MID-WESTERN REGIONAL COUNCIL

24 May 2017

SUBJECT: BERYL SOLAR FARM (SSD 8183)

**Site Development Plan**

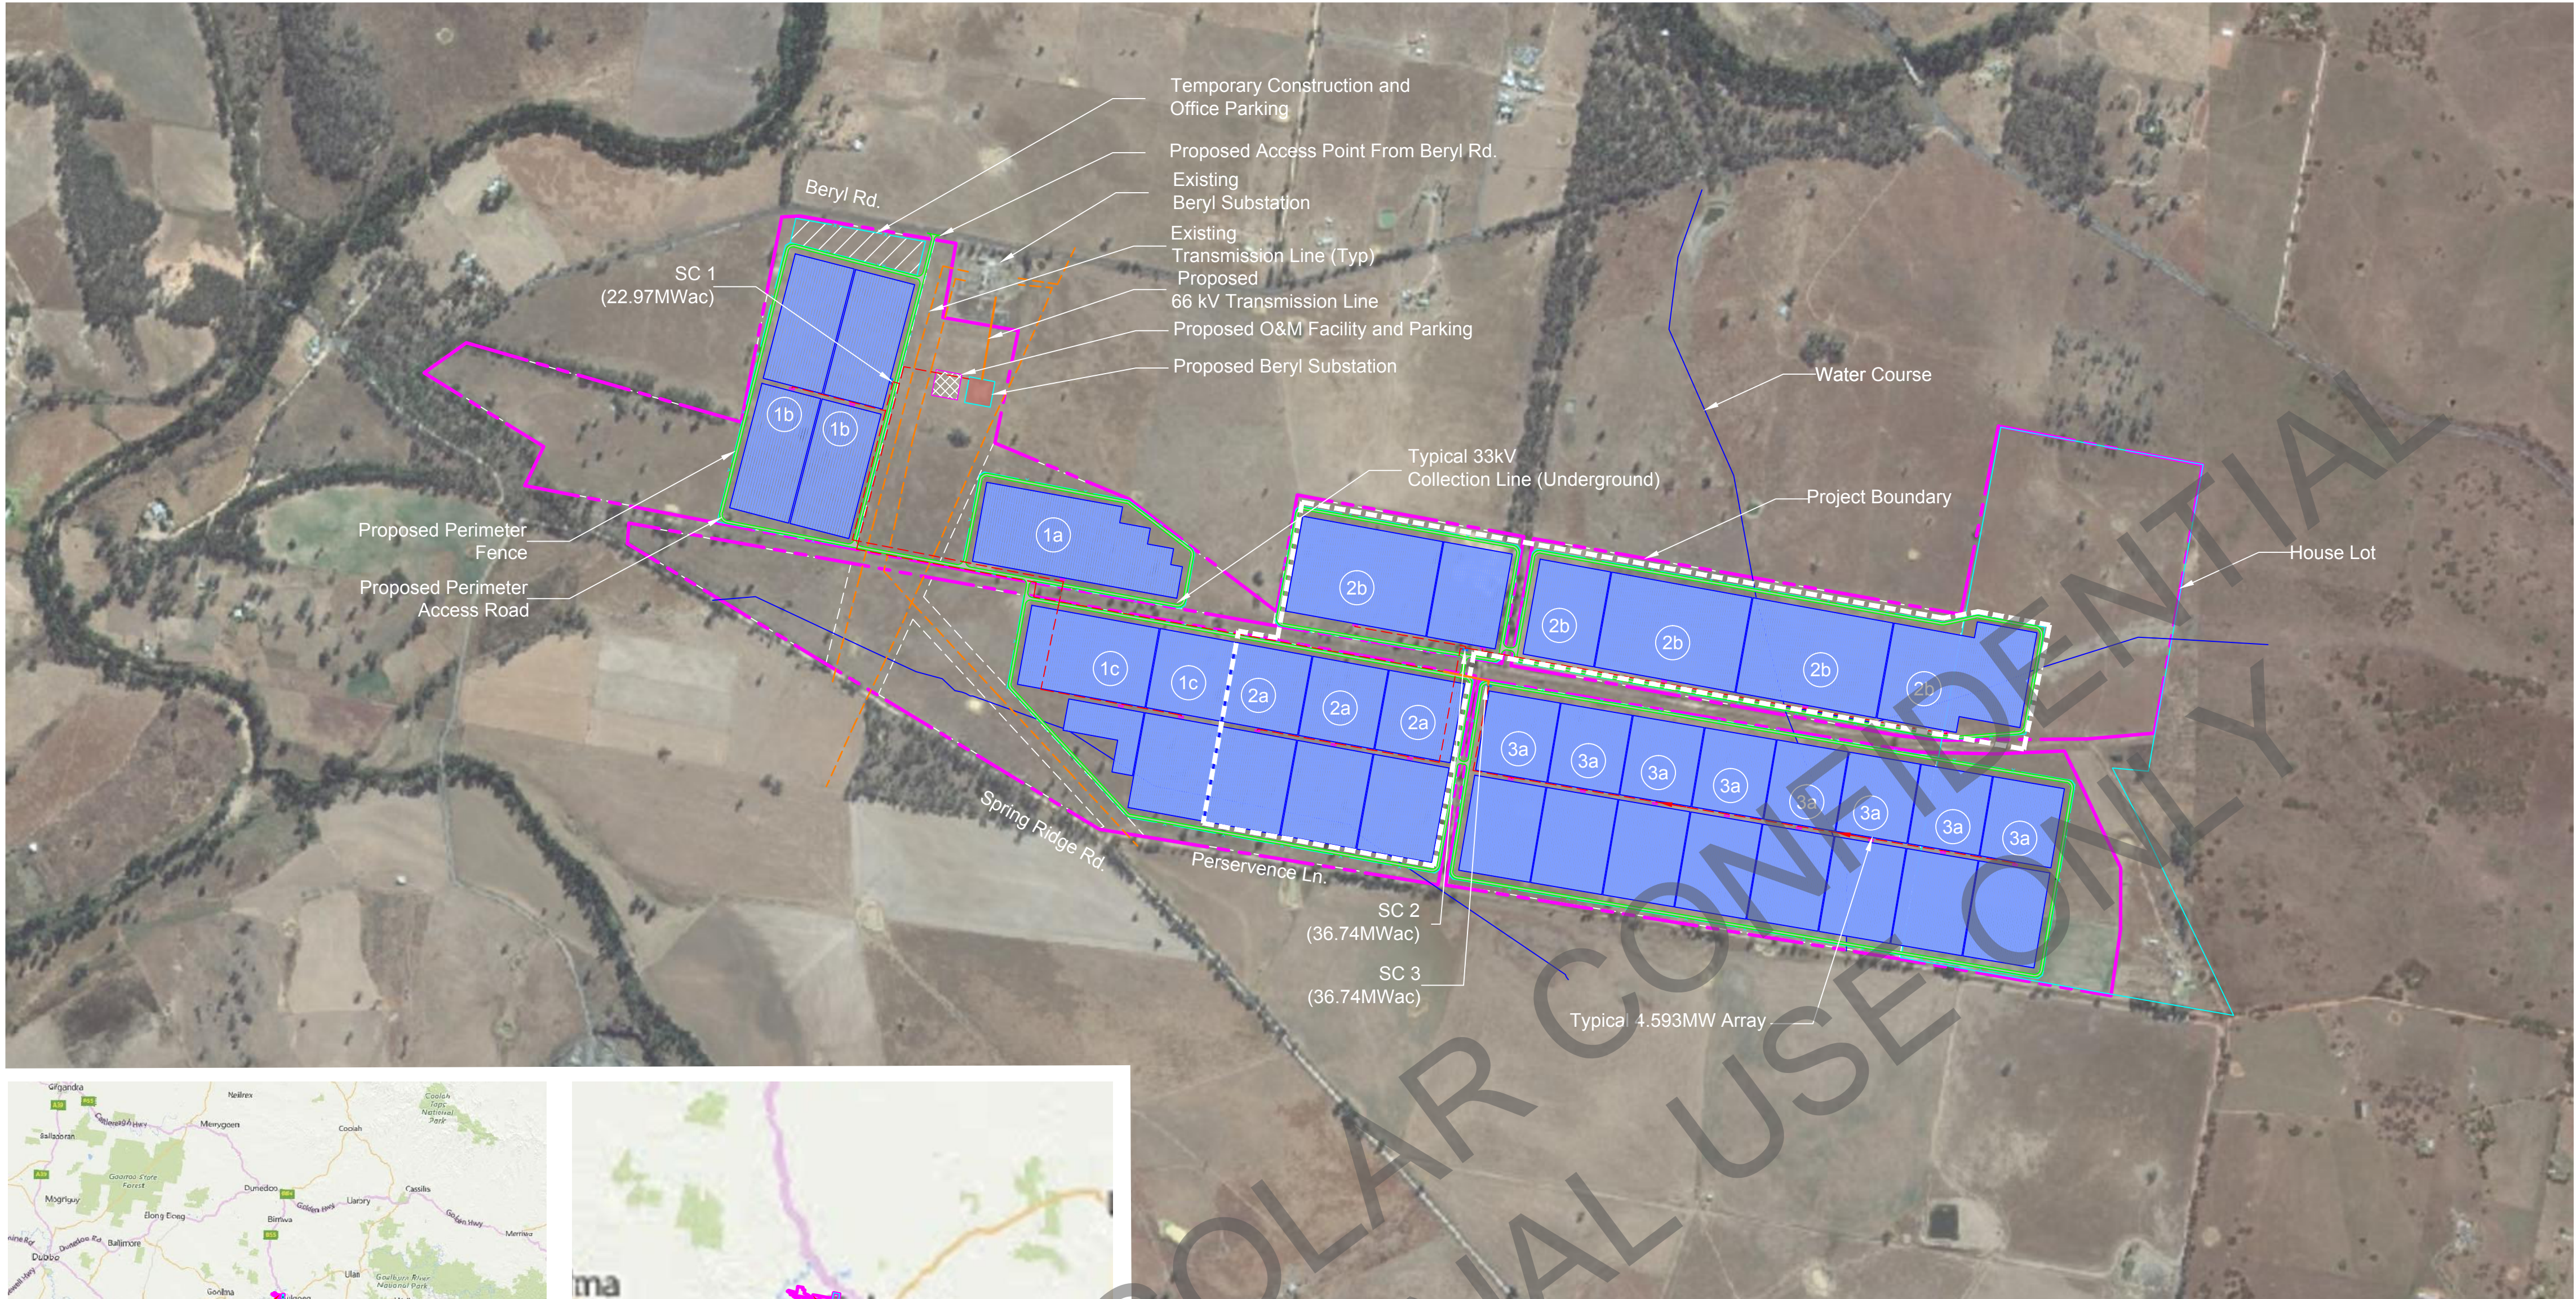
The EIS indicates that approximately 20% of the total proposed project site is located on R5 zoned land. The development of a solar farm is prohibited on land zoned R5 under the Mid-Western Regional LEP 2012. At its 17 May 2017 meeting, Council resolved not to support the solar farm occurring within the R5 zone.

It should be noted that there are some inconsistencies in the EIS regarding the total project site area. Council's records show a total site area of 309.65 ha, compared to 332 ha in the EIS. Further, there are different developed areas mentioned in the EIS (eg. 206 ha on pages 3 and 83, and 225 ha on pages 16, 25 and 136).

Visual Impact: Beryl Solar Farm to Approved Development Lot 59 DP 755434

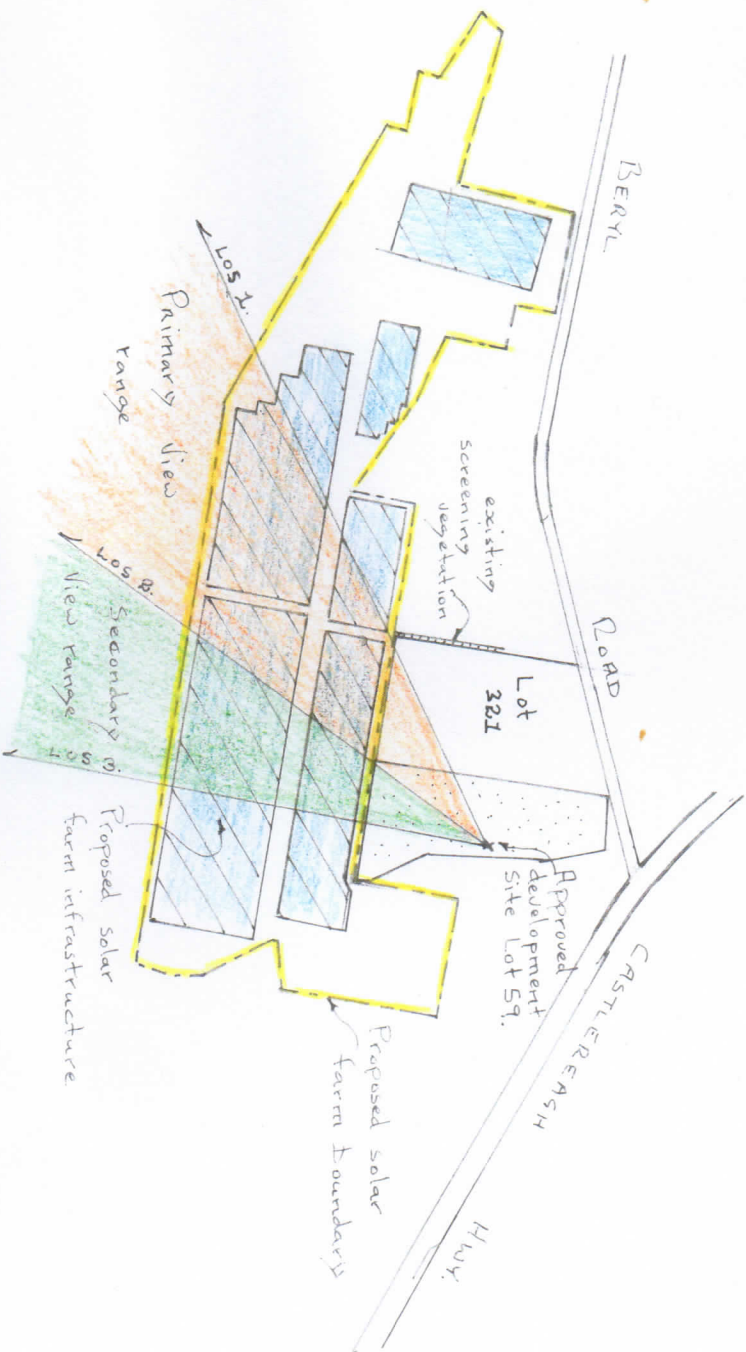
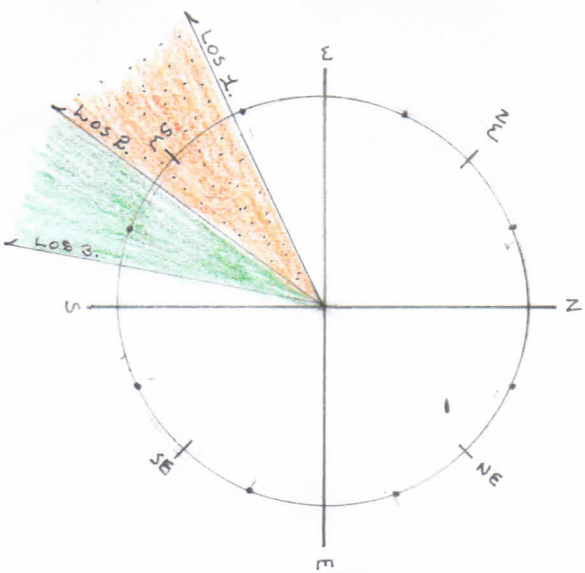
Based on the representations made to Council, the visual impacts are a serious concern for neighbouring land owners given the large scale of the project. Council strongly supports the inclusion of relevant conditions which ensure that additional screening on the site's northern boundary and north-east corner is provided as recommended in the EIS. First Solar should also ensure that all impacted land owners have the opportunity to participate and provide feedback during the development of a Visual Impact Management Plan for the project to minimise visual impacts and address concerns for their specific properties.
